Ribble Valley Borough Council
Council Offices
Church Walk,
Clitheroe
Lancashire
BB7 2RA

Phone: 0300 123 6780
Email: developeras@lancashire.gov.uk
Your ref: 3/2025/0564
3/2025/0565
Our ref: 3/2025/0564/HDC/KW
3/2025/0565/HDC/KW
Date: 14 August 2025

Location: 45 - 47 Whalley Road, Clitheroe, BB7 1EE
Proposal: Planning permission for proposed change of use from light industrial to residential (use class C3) and commercial (use class E(c)(iii)) involving internal and external alterations.
Grid Ref: 374236 441280

A Ground Floor Plan
Scale: 1:100

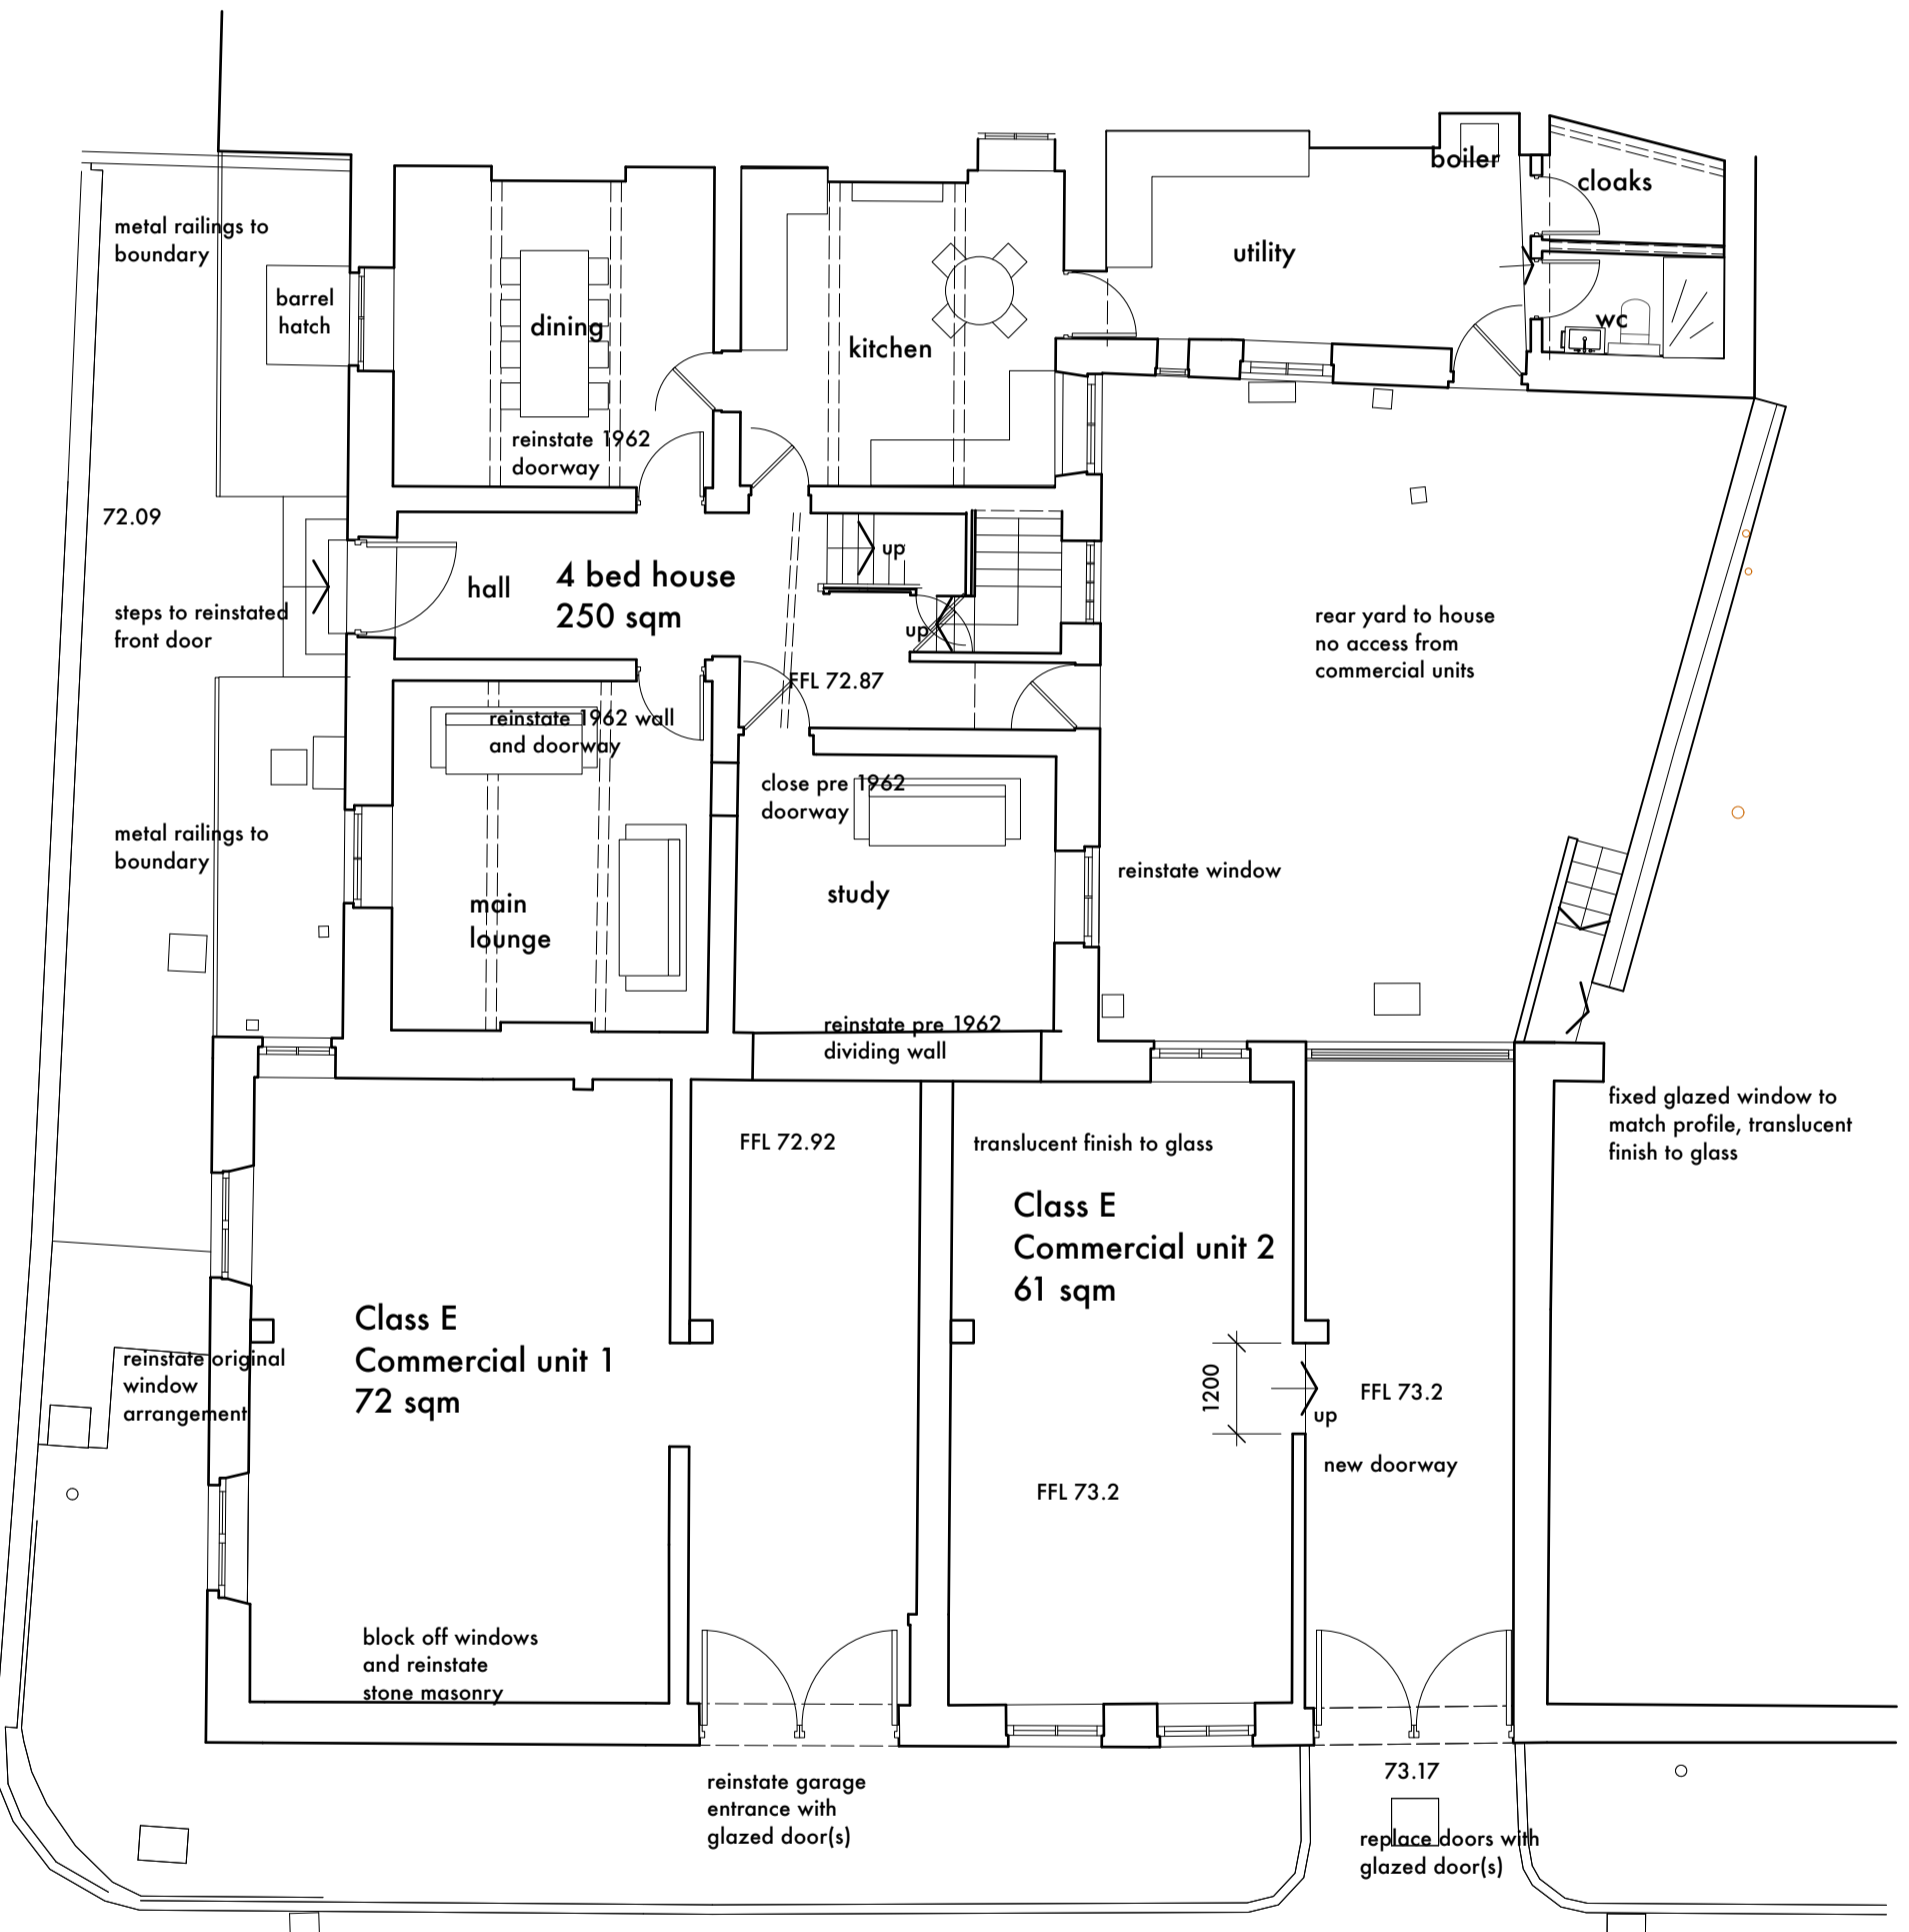
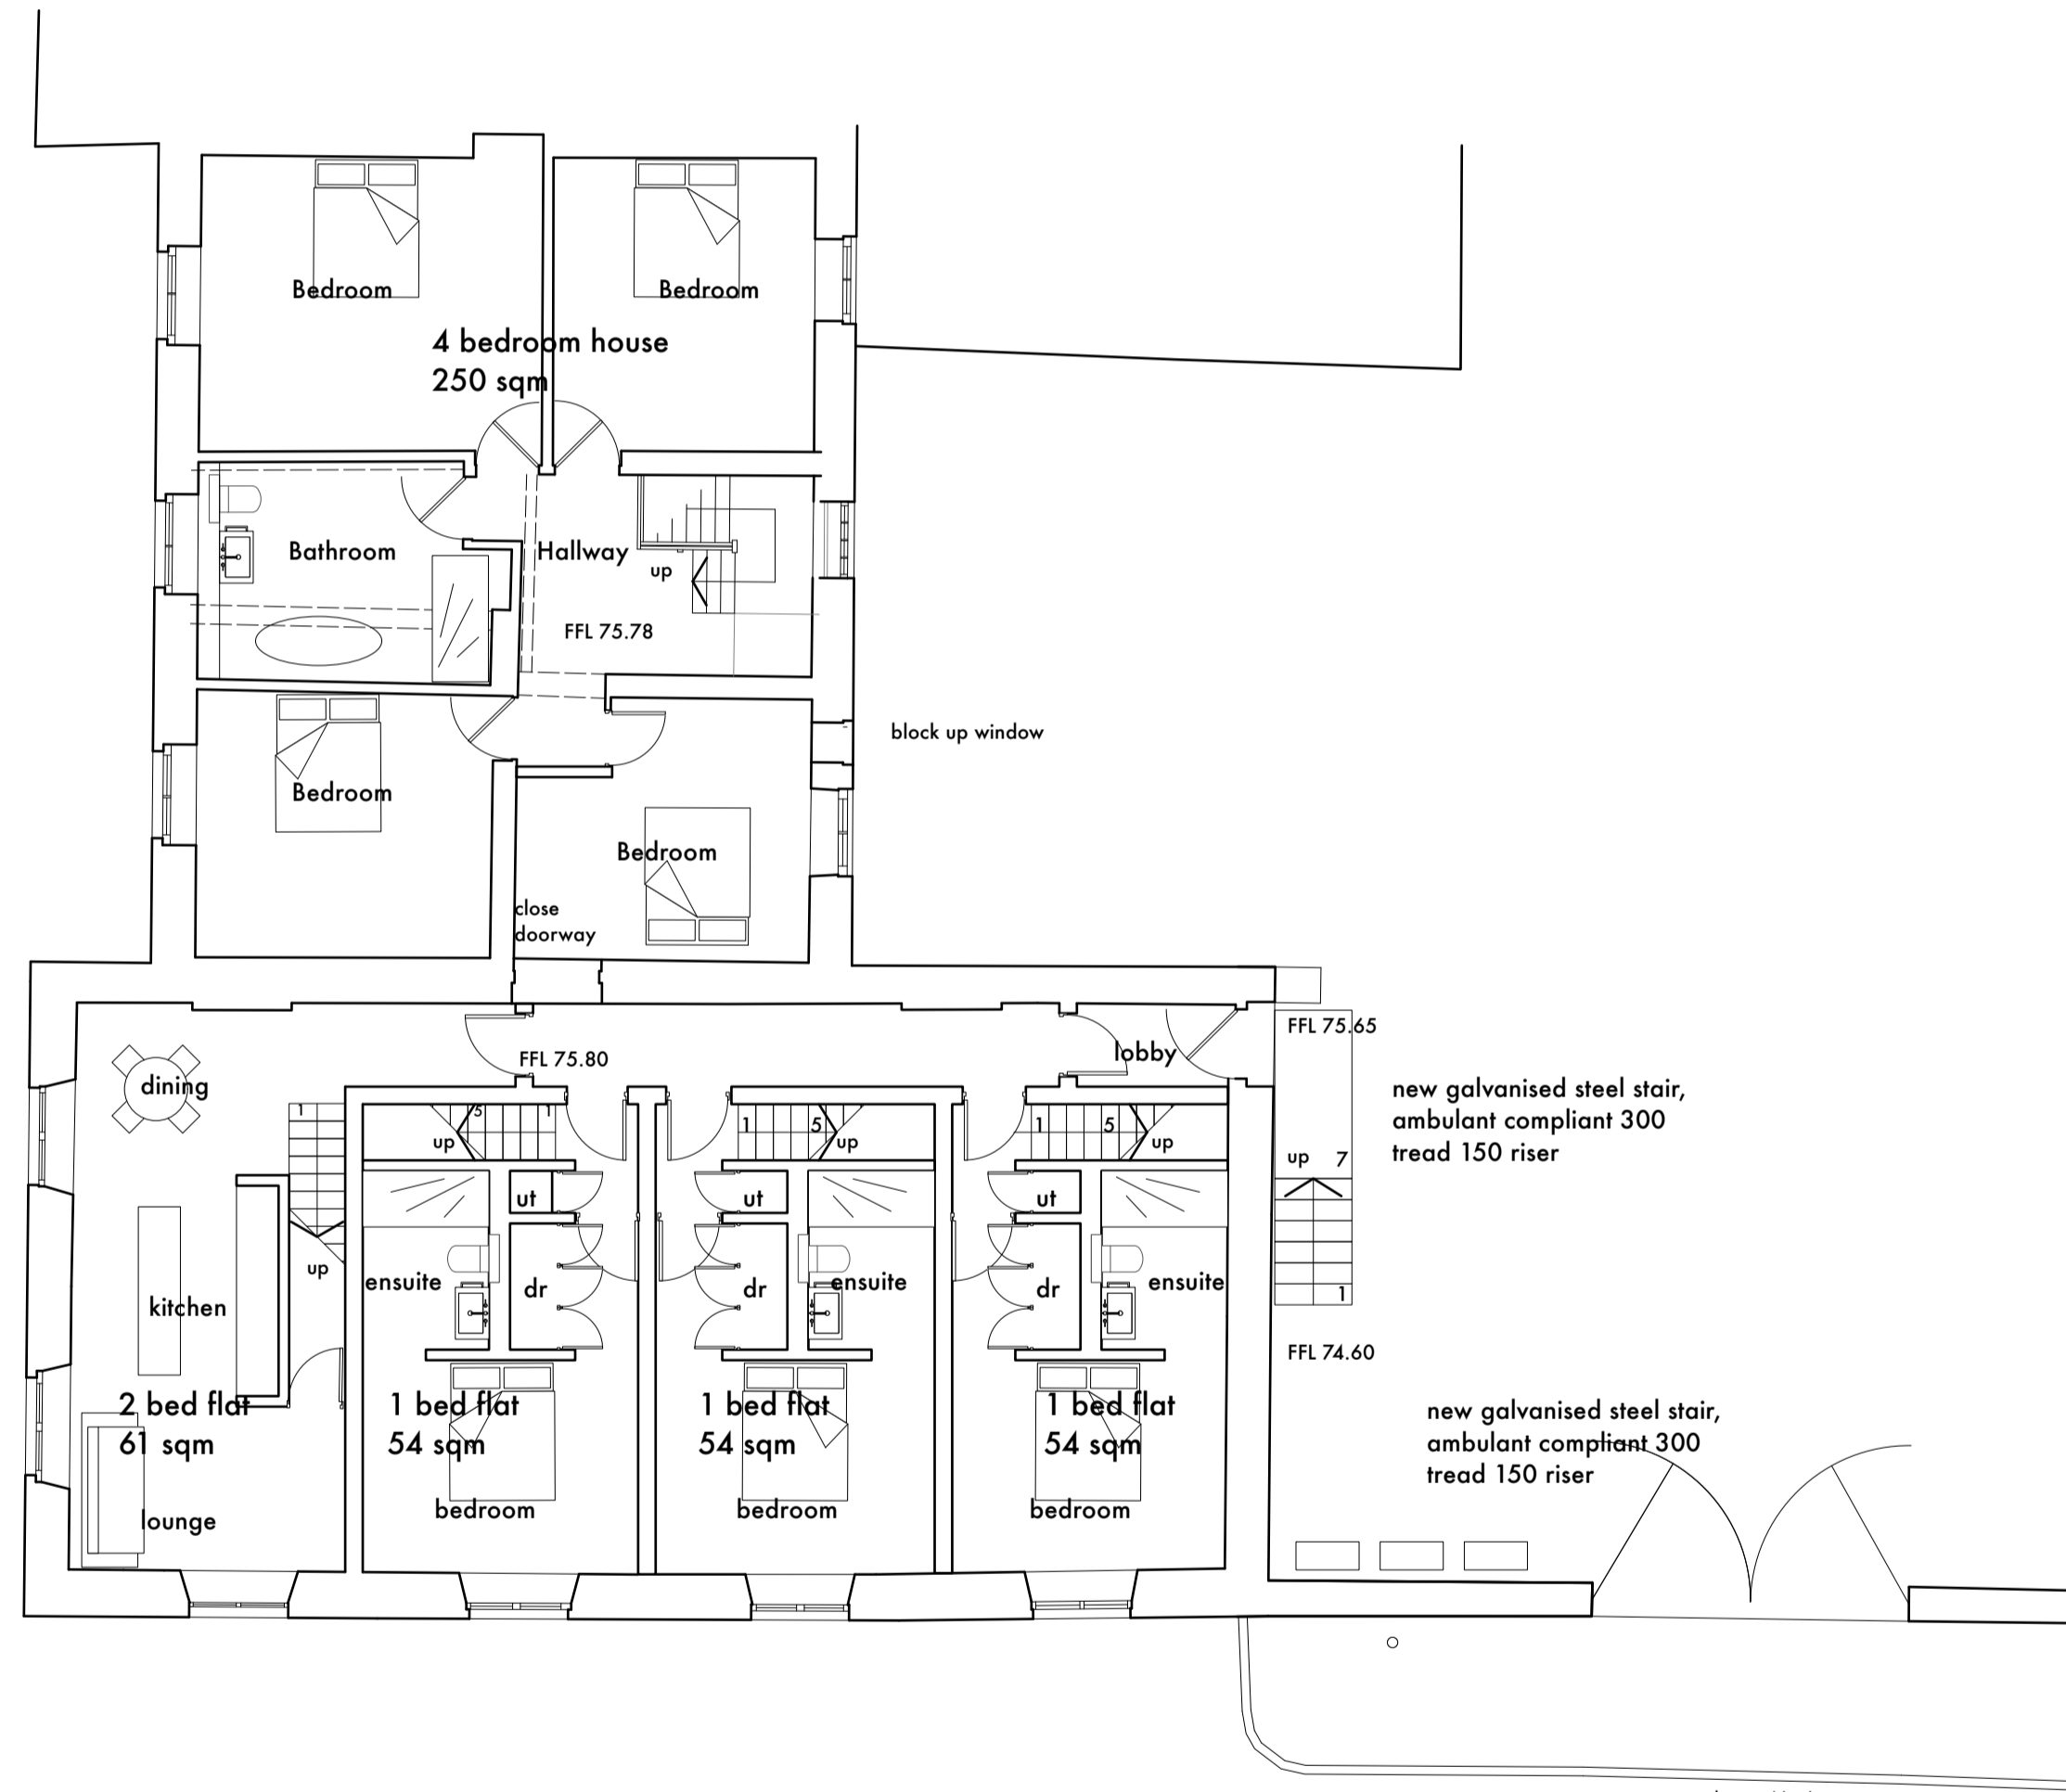
The LHA has reviewed drawing number PL01 Rev A. While concerns have been raised regarding the access arrangements, the LHA has also reviewed the parking provisions shown on the submitted plans. It should be noted that any changes to the access arrangements may affect the internal parking layout.

Currently, six parking spaces are proposed within the parking area, allocated to the residential element of the development. Two spaces are designated for the four-bedroom dwelling. The LHA would expect three off-street parking spaces for dwellings with four bedrooms or more.

Four parking spaces are allocated for the flats. Drawing number PL02 Rev A indicates that three one-bedroom flats and one two-bedroom flat are proposed. In accordance with the LHA's parking standards (as set out in the Joint Lancashire Structure Plan), one-

bedroom flats should be provided with one off-street parking space each, and two-bedroom flats should be provided with two.

Although the LHA and Ribble Valley Borough Council have not yet updated their parking standards following the introduction of Class E use, the LHA applies an average of one car parking space per 35 square metres for Class E uses. Based on the internal floor layout, Unit 1 would require two parking spaces, and Unit 2 would require one.

The LHA also has concerns regarding parking bay No. 6 due to its proximity to the gates. When fully opened, the gates would obstruct the bay, rendering it unusable. The applicant should also consider cycle and refuse storage provisions, which are likely to be accommodated within the outdoor/parking area.

Given the above, the LHA recommends that the applicant reconsider the parking layout and overall provision within the site.
